Mallard Pass Solar Farm

Environmental Statement Volume 2 Appendix 9.3: Highways and Access - Consultation Summary

Appendix 9.3 - Consultation Record and Responses Relevant to Highways and Access

Table 1: Key Matters Raised during Consultation in Relation to Highways and Access

A1621 ESSENDINE ROAD / UFFINGTON LANE WORKS

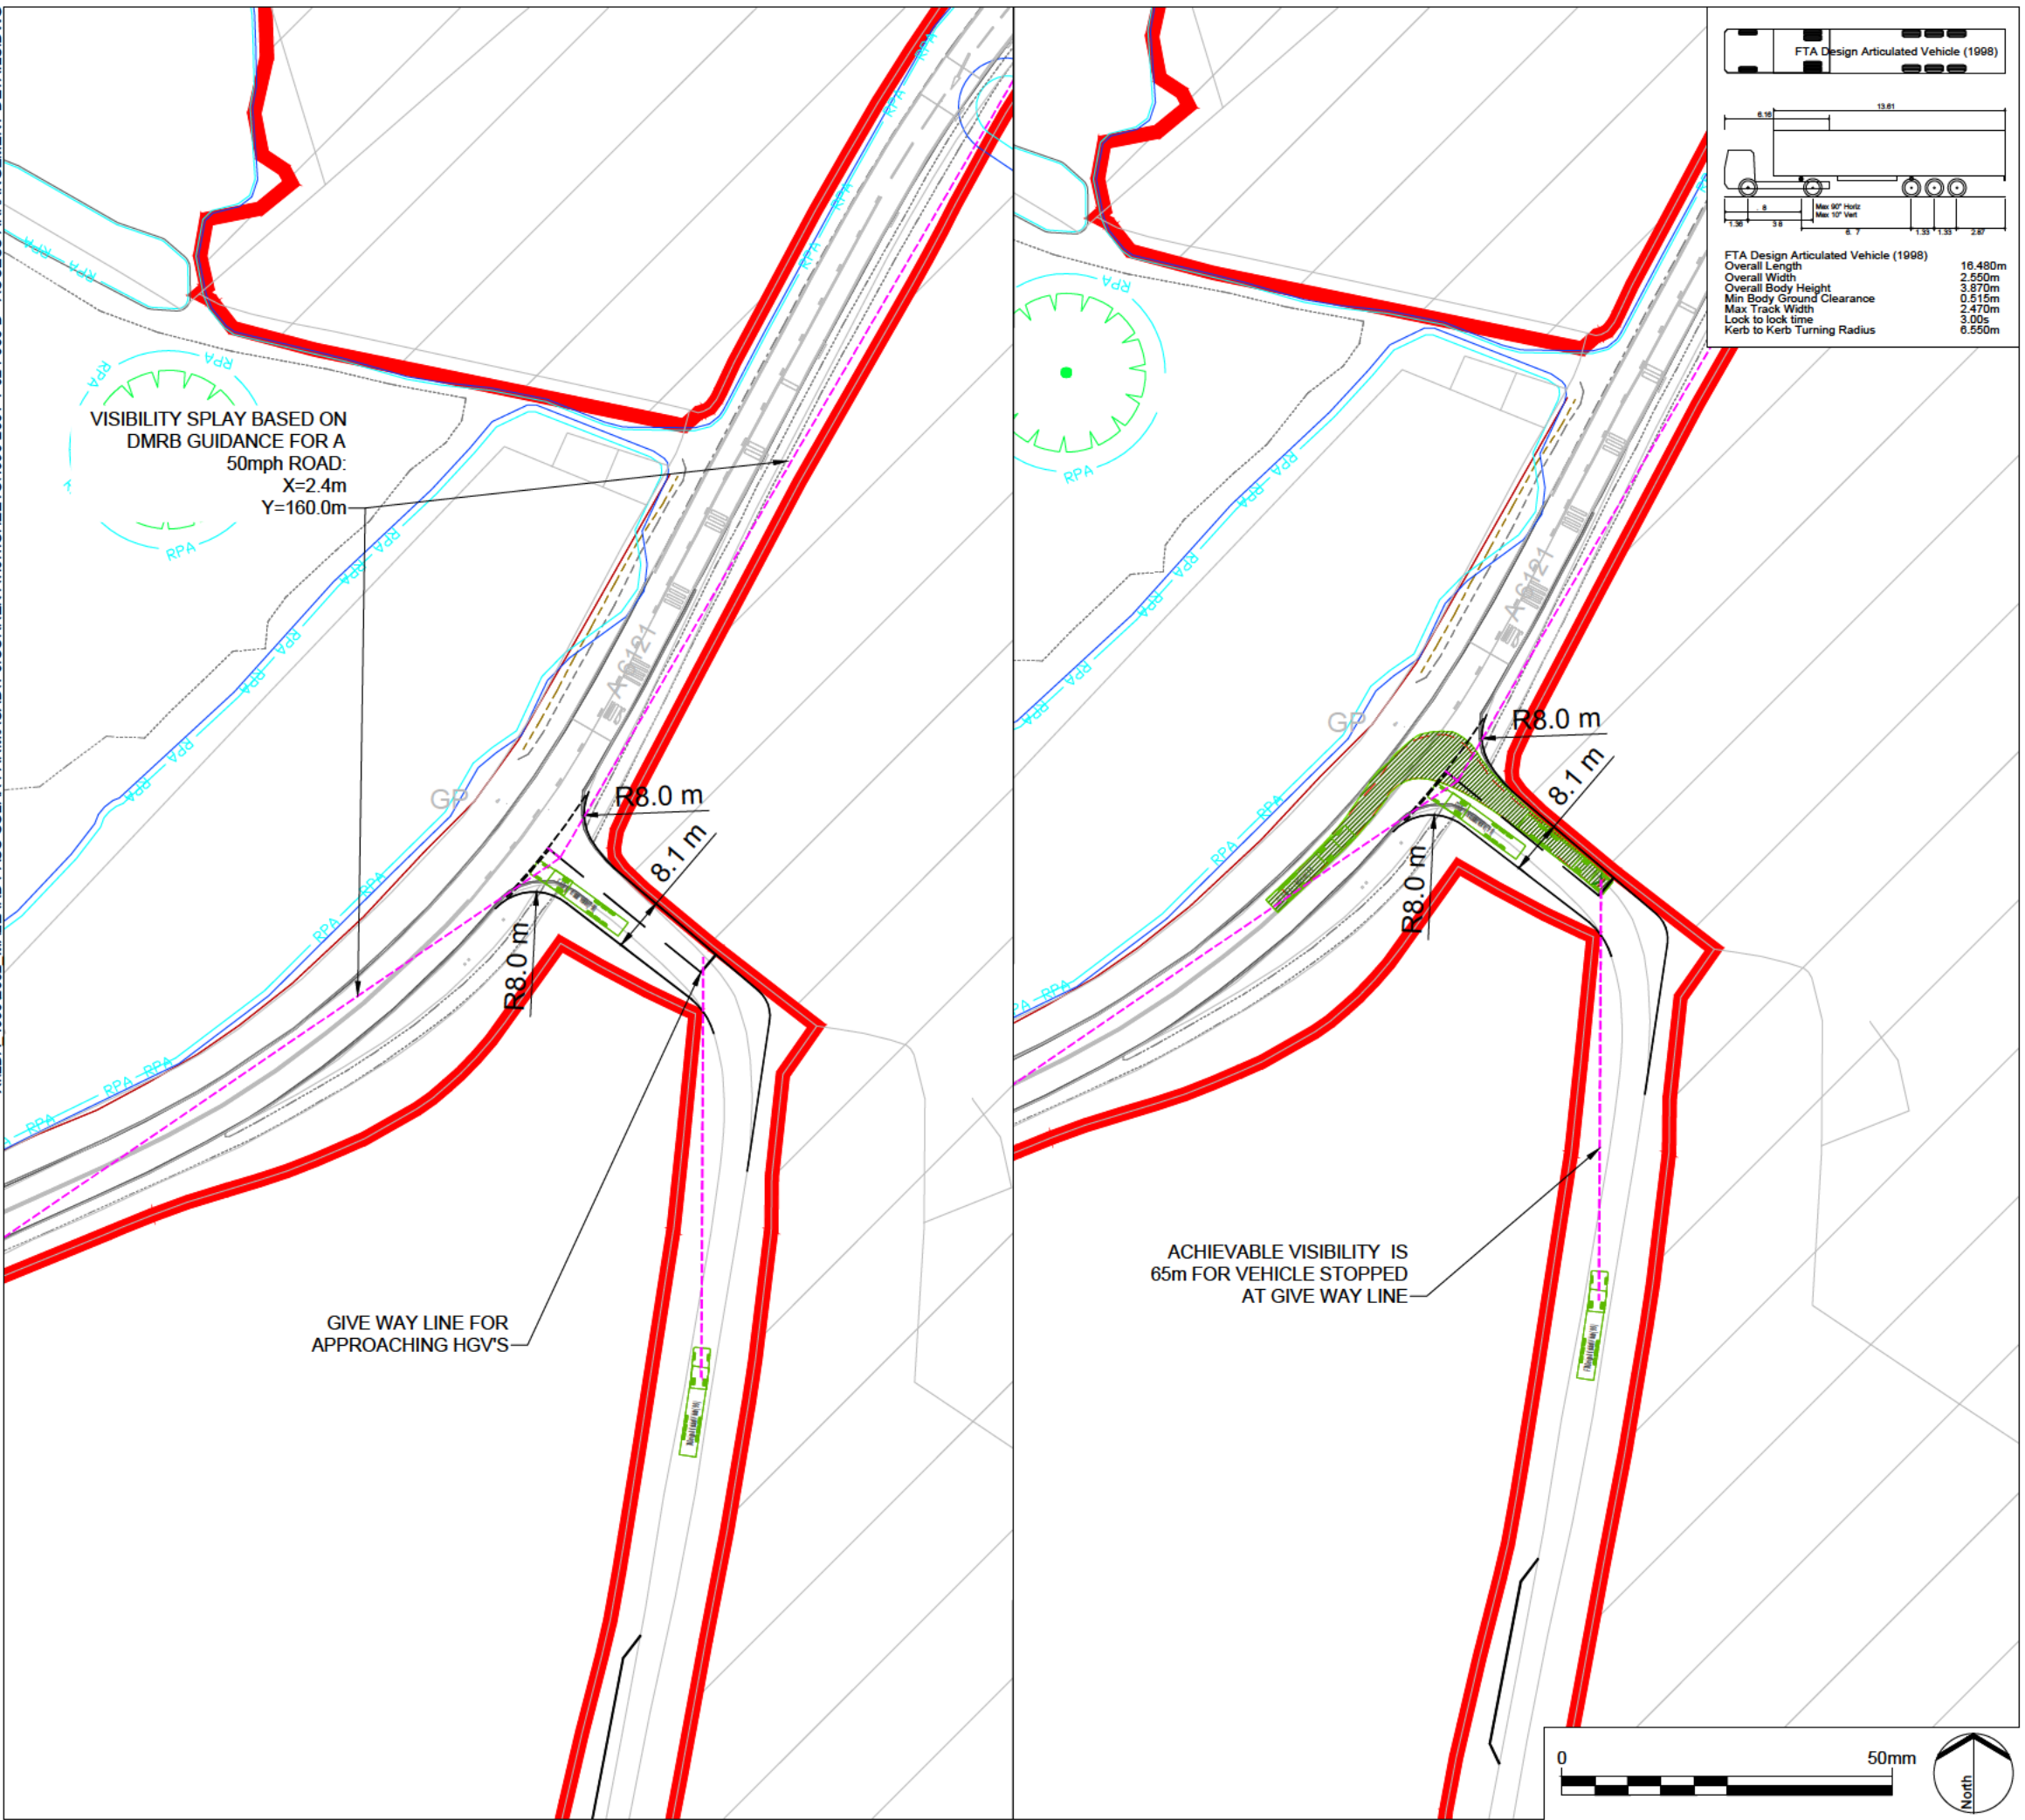
<p>RCC commented on the use of Uffington Lane and that passing places would be required.</p>	<p>Proposals to introduce passing bays and improve the Uffington Lane junction have been developed.</p>	<p>Within the embedded mitigation summary at Section 9.4 of Chapter 9. The timescales for the delivery of these works are discussed within the CTMP.</p>
